**Enguang Lee - Online Submission from Joanne Bellette (other)**

Submission for Job: #2483 08\_0080 Project Application  
[https://majorprojects.onhiive.com/index.pl?action=view\\_job&id=2483](https://majorprojects.onhiive.com/index.pl?action=view_job&id=2483)

Site: #1566 Lyons Road, North Bonville  
[https://majorprojects.onhiive.com/index.pl?action=view\\_site&id=1566](https://majorprojects.onhiive.com/index.pl?action=view_site&id=1566)

Preliminary Subdivision Concept Layout - Lyons Road, North Bonville

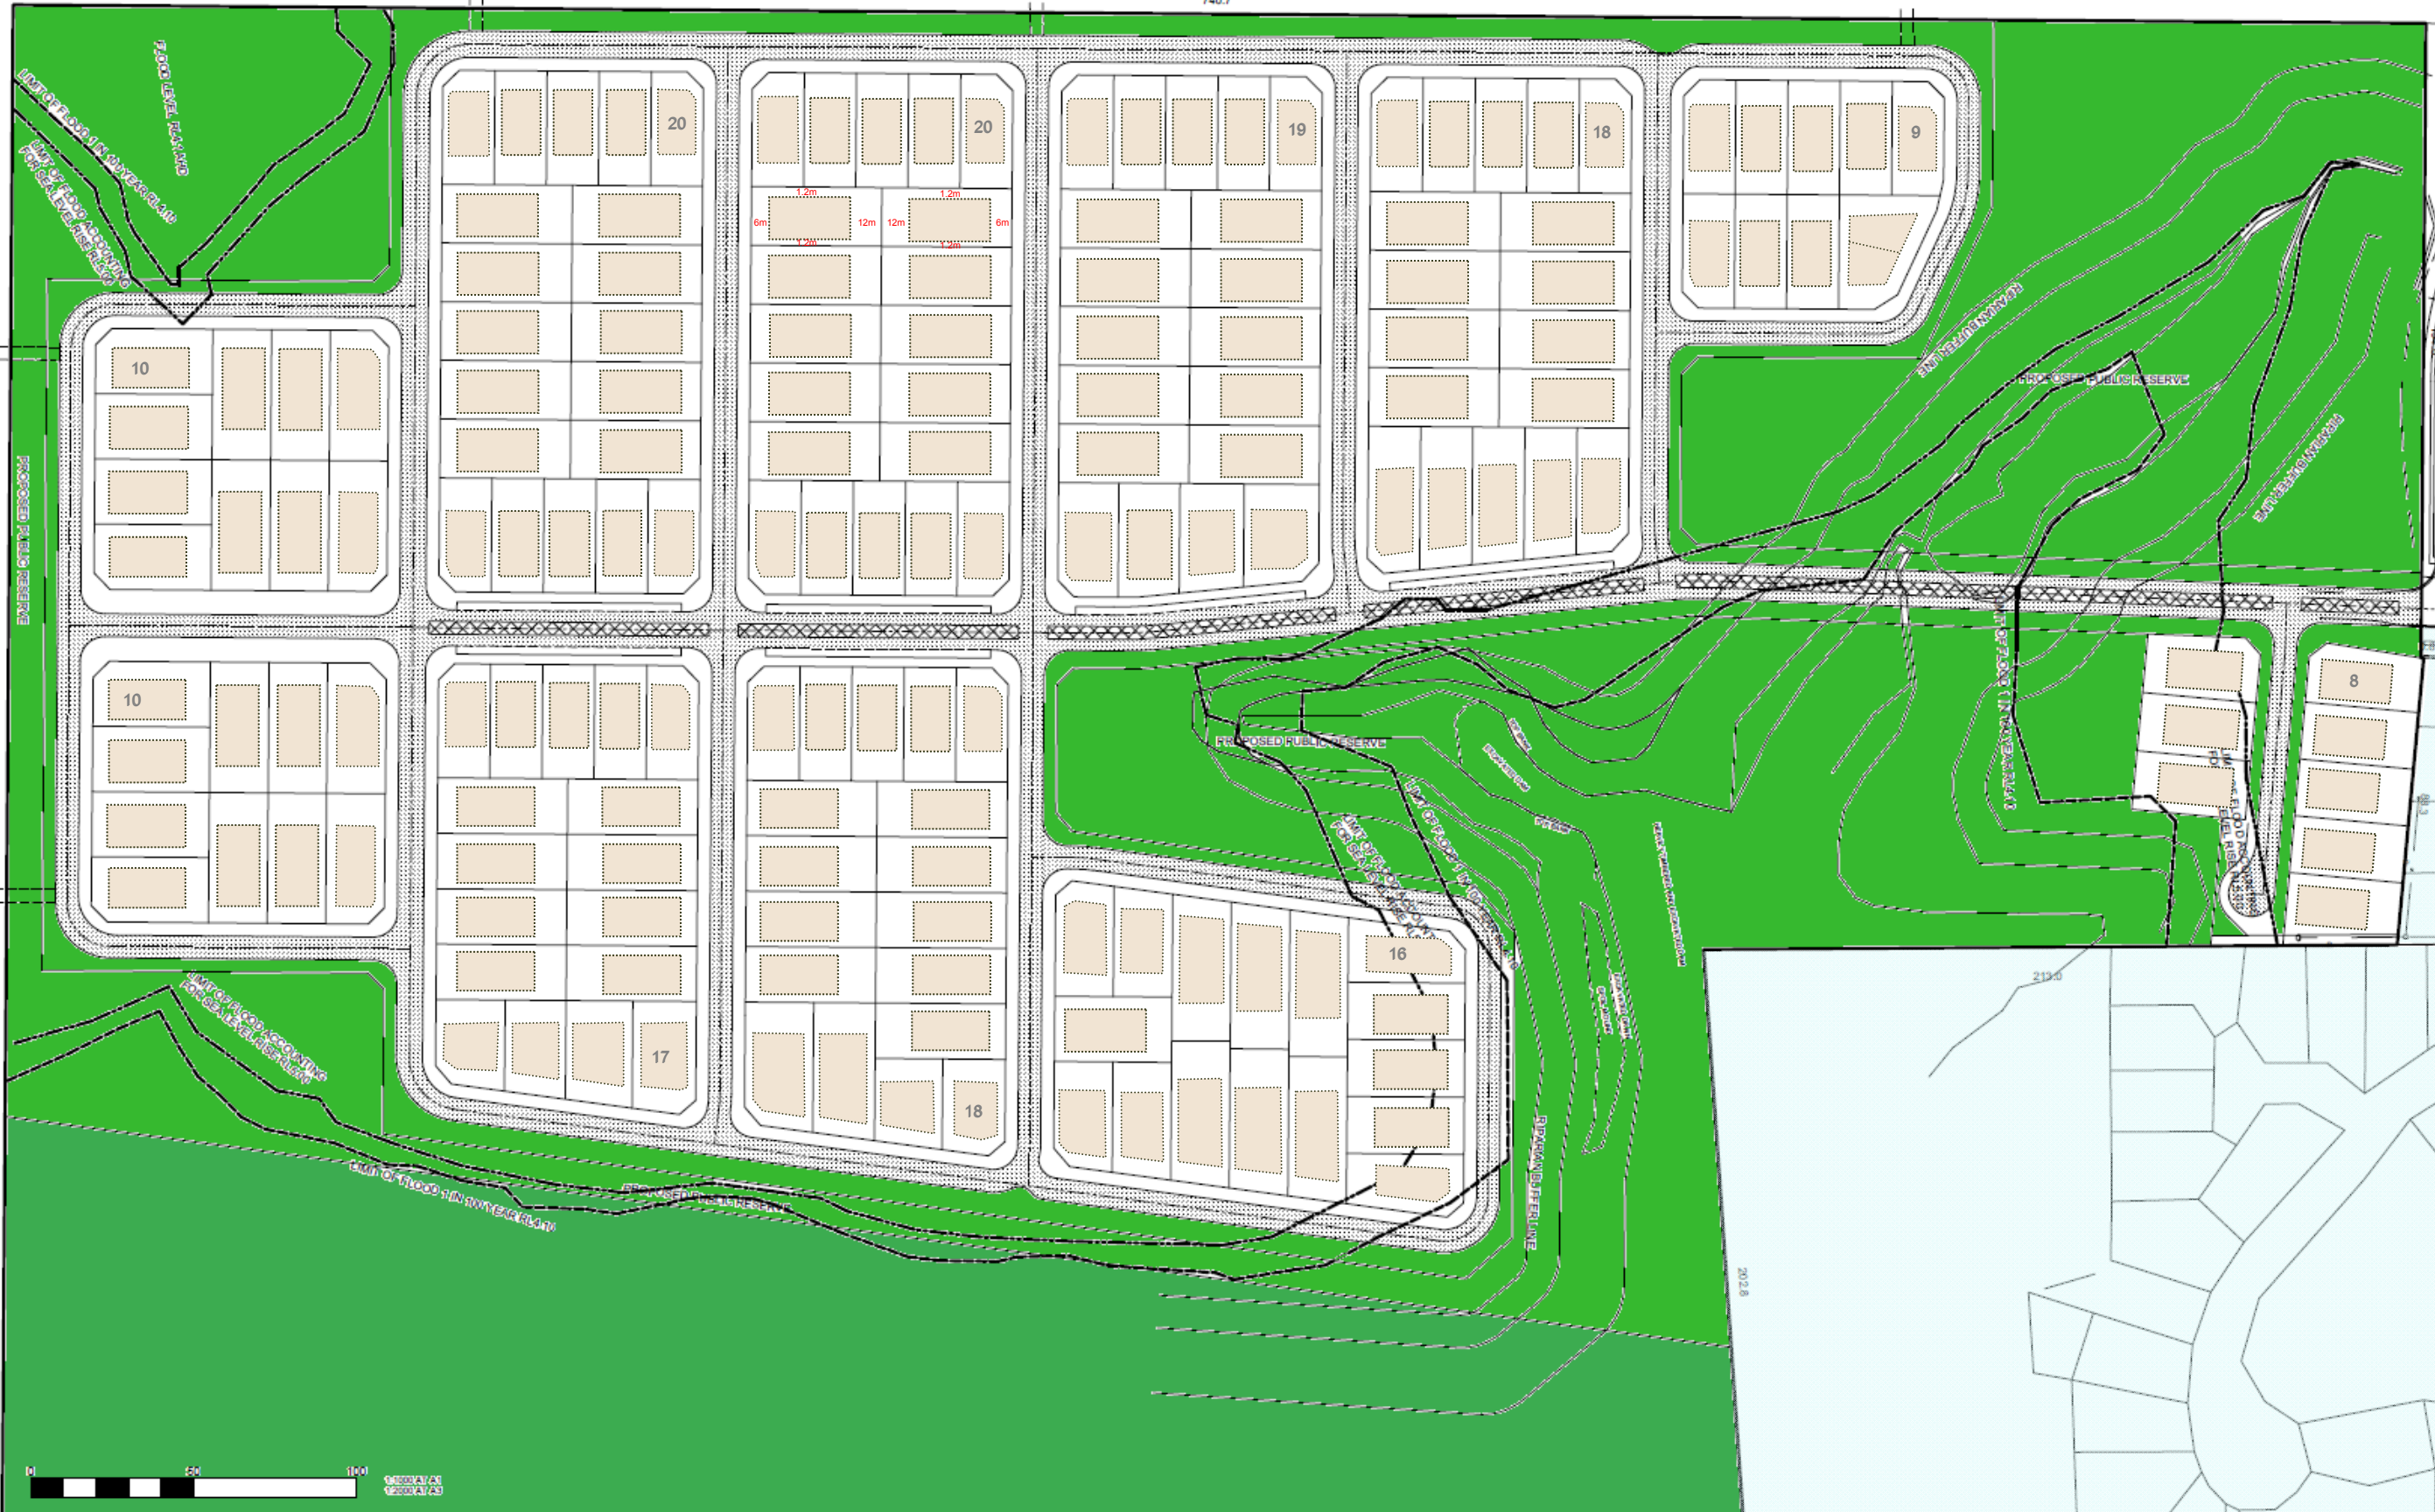
My husband, Matthew, and I would like to request the inclusion of a children's playground in the design of this subdivision. Given that the land is targeted at family housing, and the current lack of children's playground facilities in the nearby area, I believe this would be an important inclusion for the residents in this area.

Whilst I note that the design includes the 'indicative location for a future children's playground' my husband and I are concerned that this is clearly not a priority in the development of this land and that it may be left incomplete after all of the land has been sold. We believe that it is crucial that a children's playground be included not as an 'indicative location' but rather as an essential element in the building and development program which should take some priority because of its important contribution to the community.
